MORECAMBE GENERATION OFFSHORE WIND FARM

**Appendix B12 to Natural England's Deadline 5a Submission**

**Natural England's comments on the Applicants Lesser Black Backed Gull  
Compensation Quantum**

Planning Inspectorate Reference EN010121

Yellow = scrub clearance area A (c. 0.60ha)

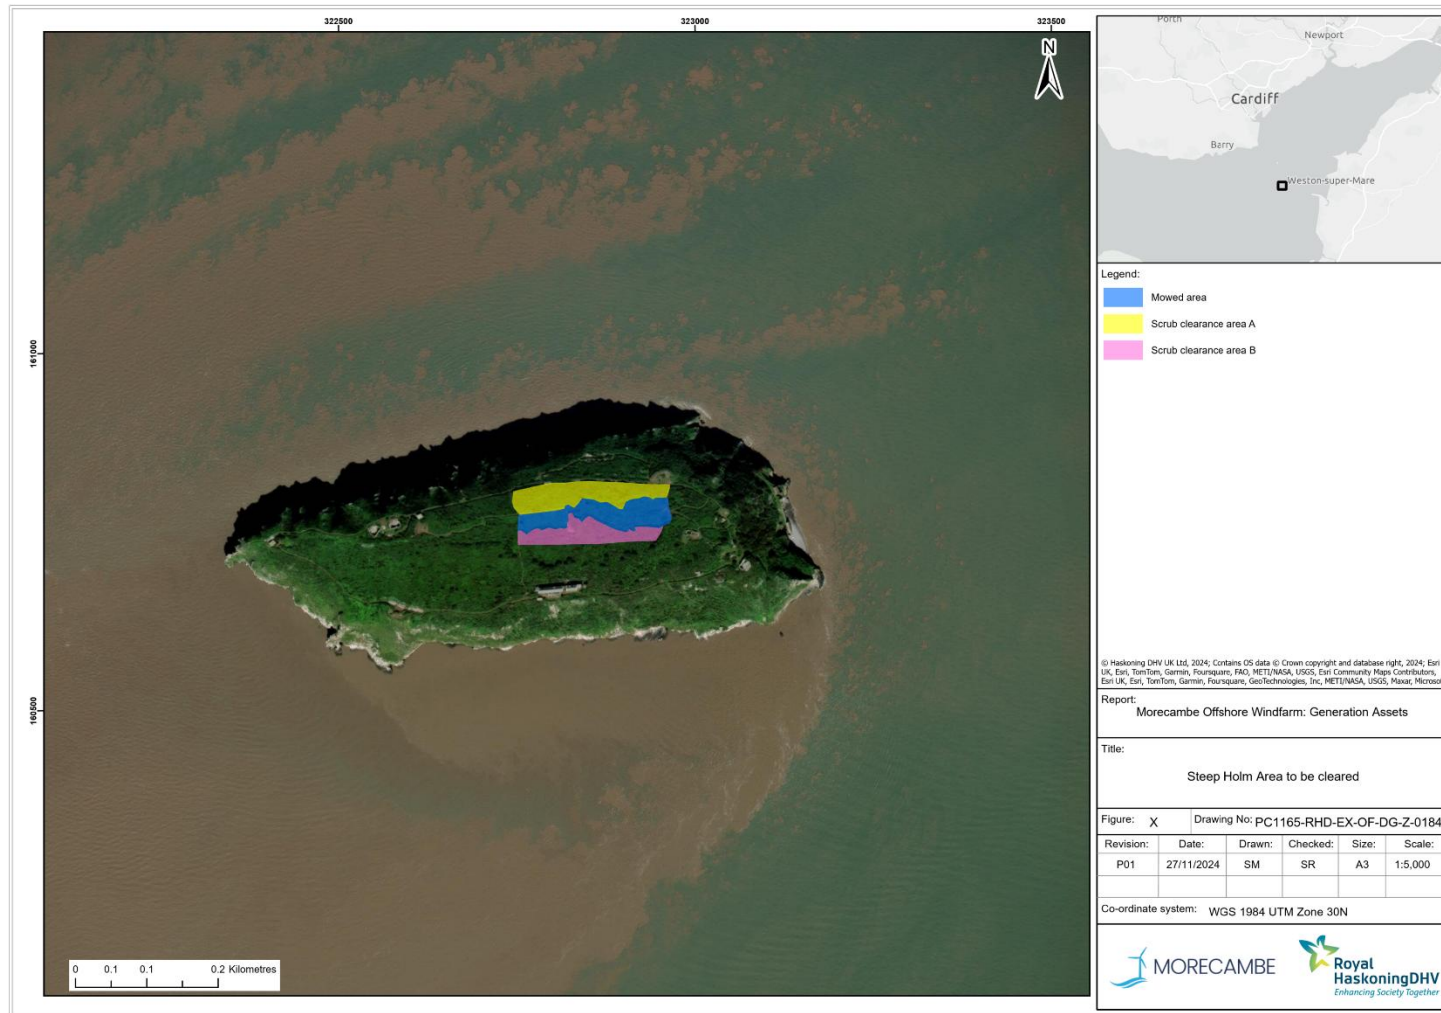
Thus, we consider that the compensatory measure should be scaled using the UCL impact value, applying the H4 method with additional consideration of philopatry to derive the quantum, and then applying a 3:1 ratio to generate the number of pairs the measure should be able to accommodate. Finally likely nesting densities should be considered to define a minimum area of scrub clearance.

We calculate that this means that the measure should be scaled to provide sufficient space to potentially accommodate at least **100** nesting pairs. This will require the clearance and management of at least **0.21 Ha** of scrub to create suitable nesting habitat (see Calculation 2). This equates to an area of approximately a third of a football pitch.
